In the ES the applicant states (para 2.1.6) "It is likely that the NGET substation will be located in one of two possible locations;

1. On land within the Order Limits, at the Southern Site, at the western most extremity, south of the Farmoor Reservoir; or
2. On land near and to the West of the Applicant's Southern Site, south of the Farmoor Reservoir."

**Operational Development Plan
Southern Site Area**

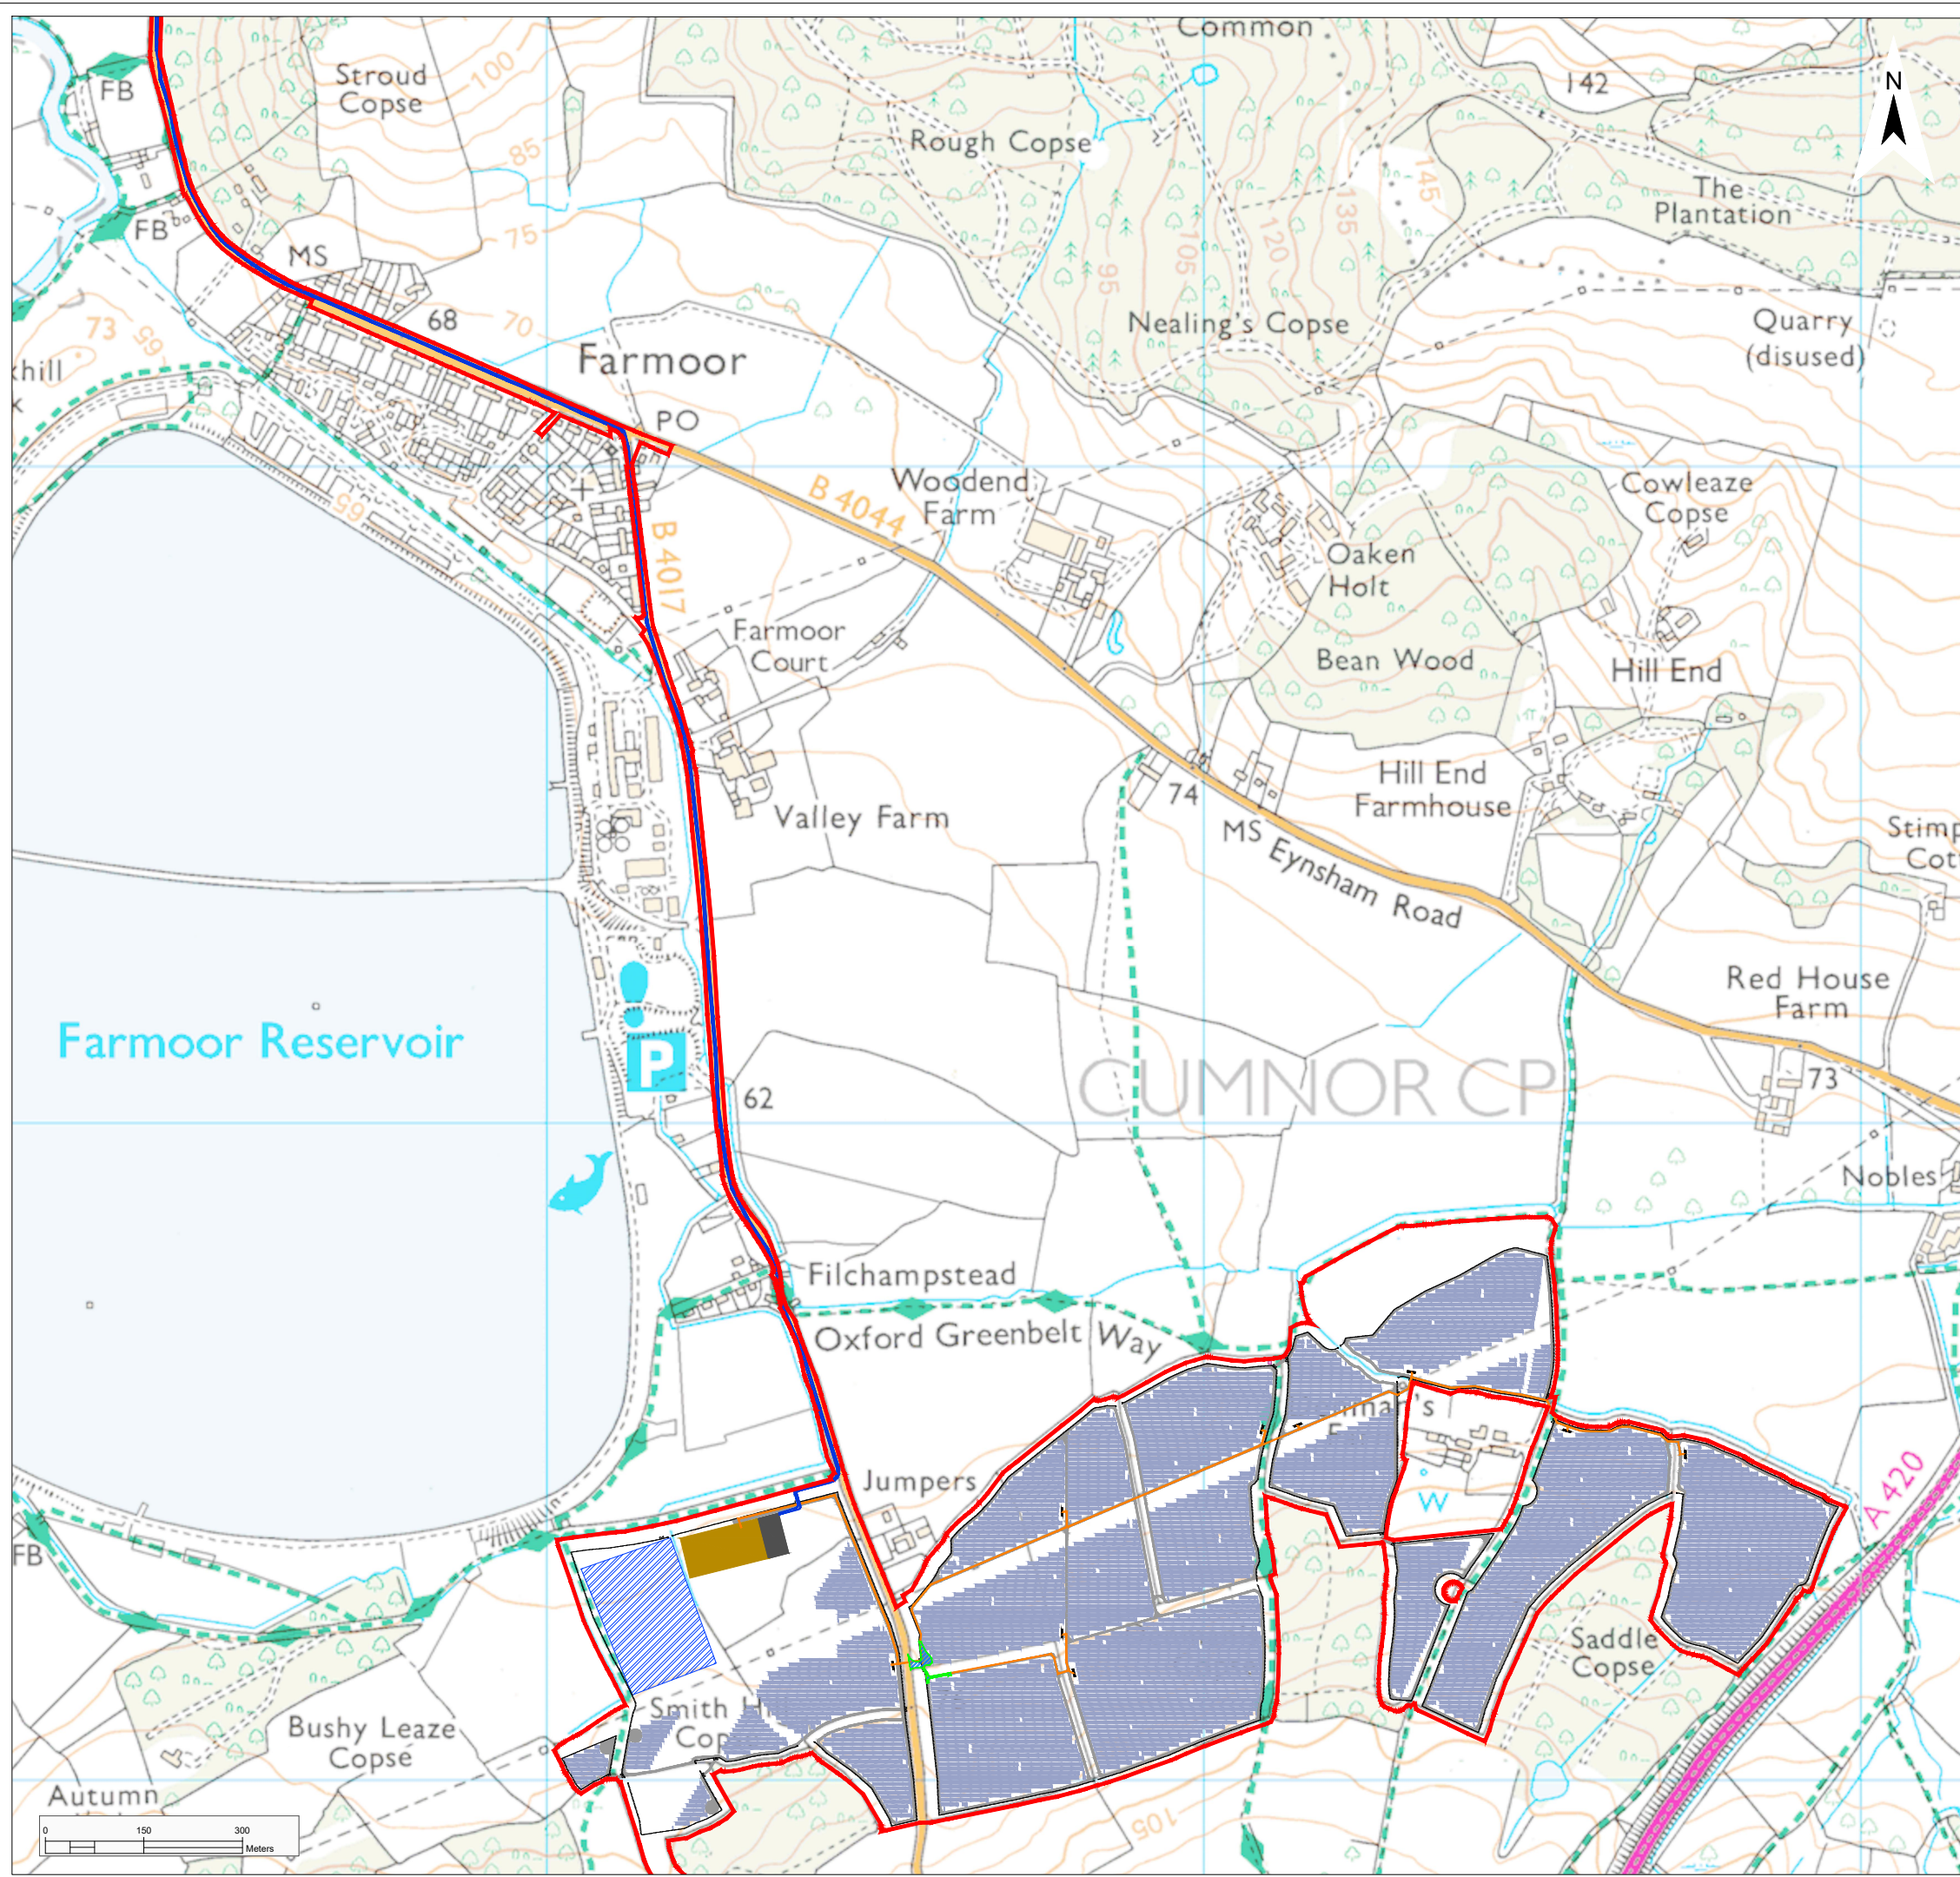
I accept that the new substation has to be located in close proximity to the existing high voltage line that crosses Cumnor Parish but I can find no explanation for why the choice of sites for the substation is so limited. Why has the applicant assumed that these are the only two locations that should be considered?

The building of the substation is a permanent change of use and will have a profound impact on the visual landscape both as a piece of industrial development and because of the likelihood of the construction of additional pylons. In these circumstances, would it not be desirable and appropriate for the advantages and disadvantages of other locations so as to minimise the visual impact?
